Planning application no.: 3.25.0701

Proposal: Listed Building Consent for proposed subdivision of shop premises to accommodate living accommodation on first and second floor for use as letting apartment

Location: 33 Castle Street, Clitheroe

Application No:	25/	
Local area council:	Ribble Valley B C	
Previous application No:		
Drawing Number :	Amended Dwg 00153V2	
Drawn:	PCD	
Scale:	Size:	Subject:
1:200	A3	Site and boundary details

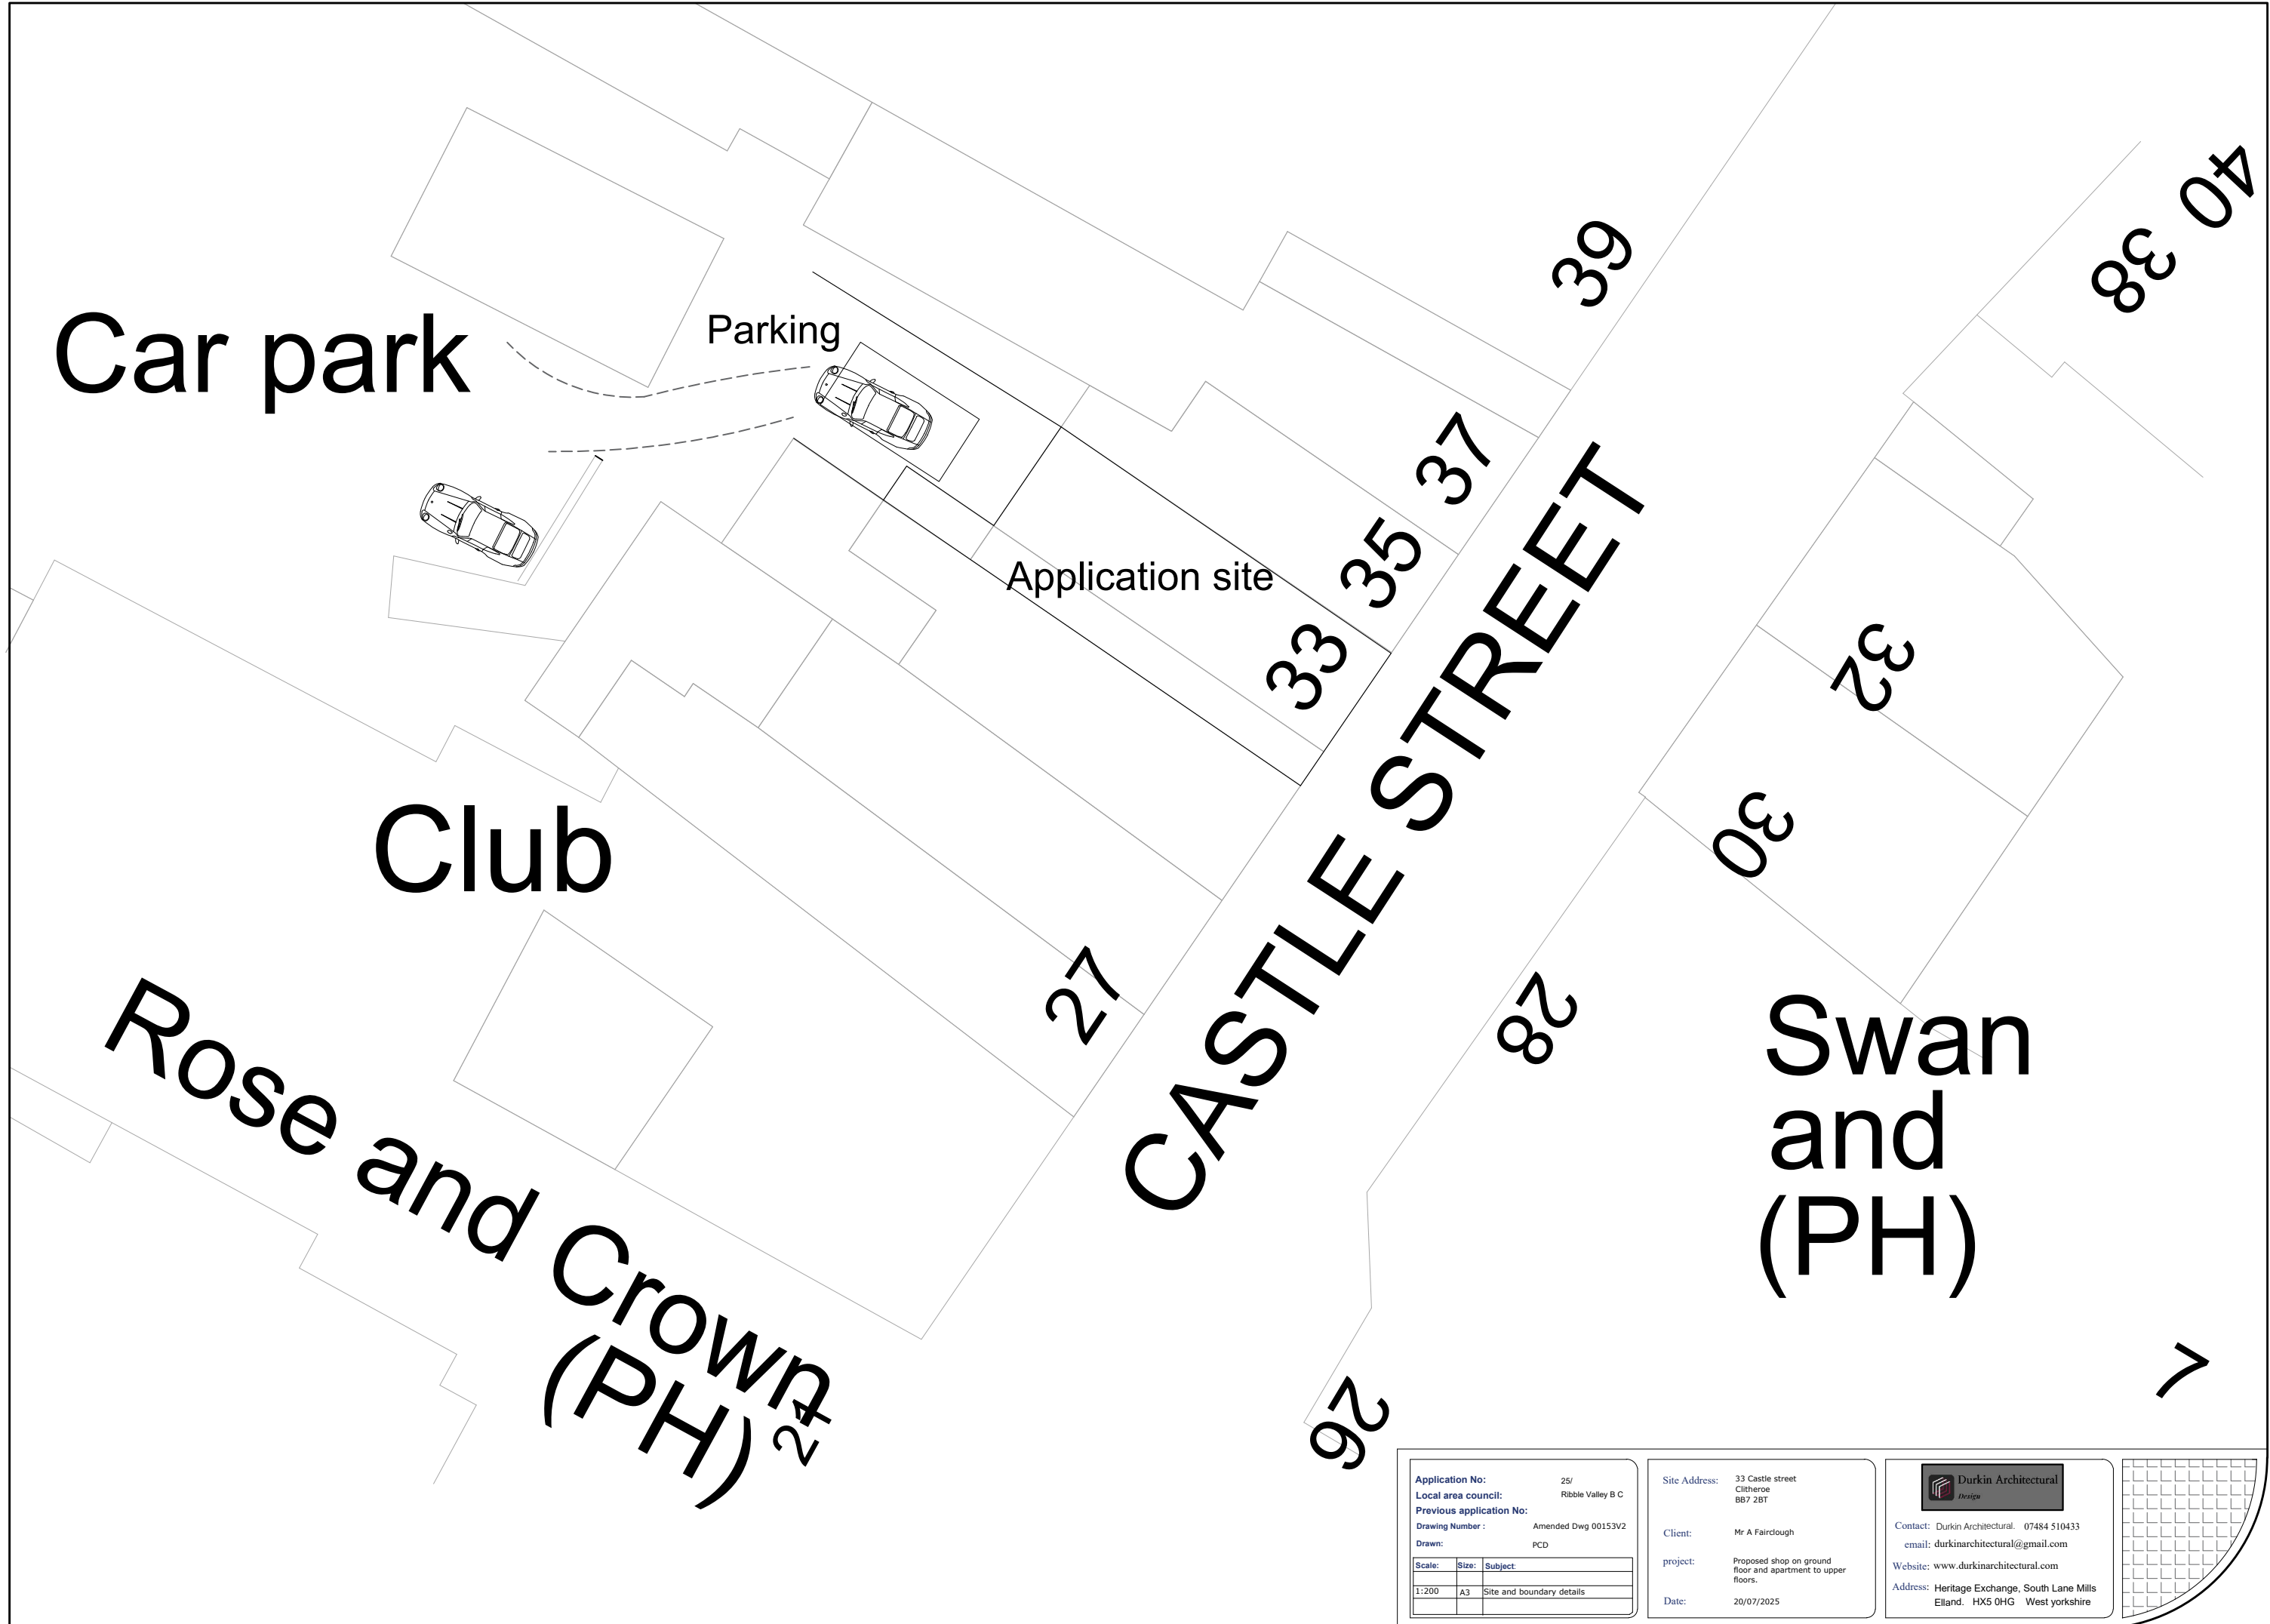
No parking exists for the site only on street or local car parks, however, It is noted access has been agreed to the rear of the building for parking (ref. Amended Drawing 00153V2, dated 20/7/25, Site boundary details) for the 2-bed apartment. The proposal is in a sustainable location with access to local amenities and is on a bus route.

- The parking spaces as indicated on Amended Drawing 00153V2, dated 20/7/25 (Site boundary details) hereby approved shall be made available prior to the use hereby approved first becoming operative and thereafter be retained in perpetuity.
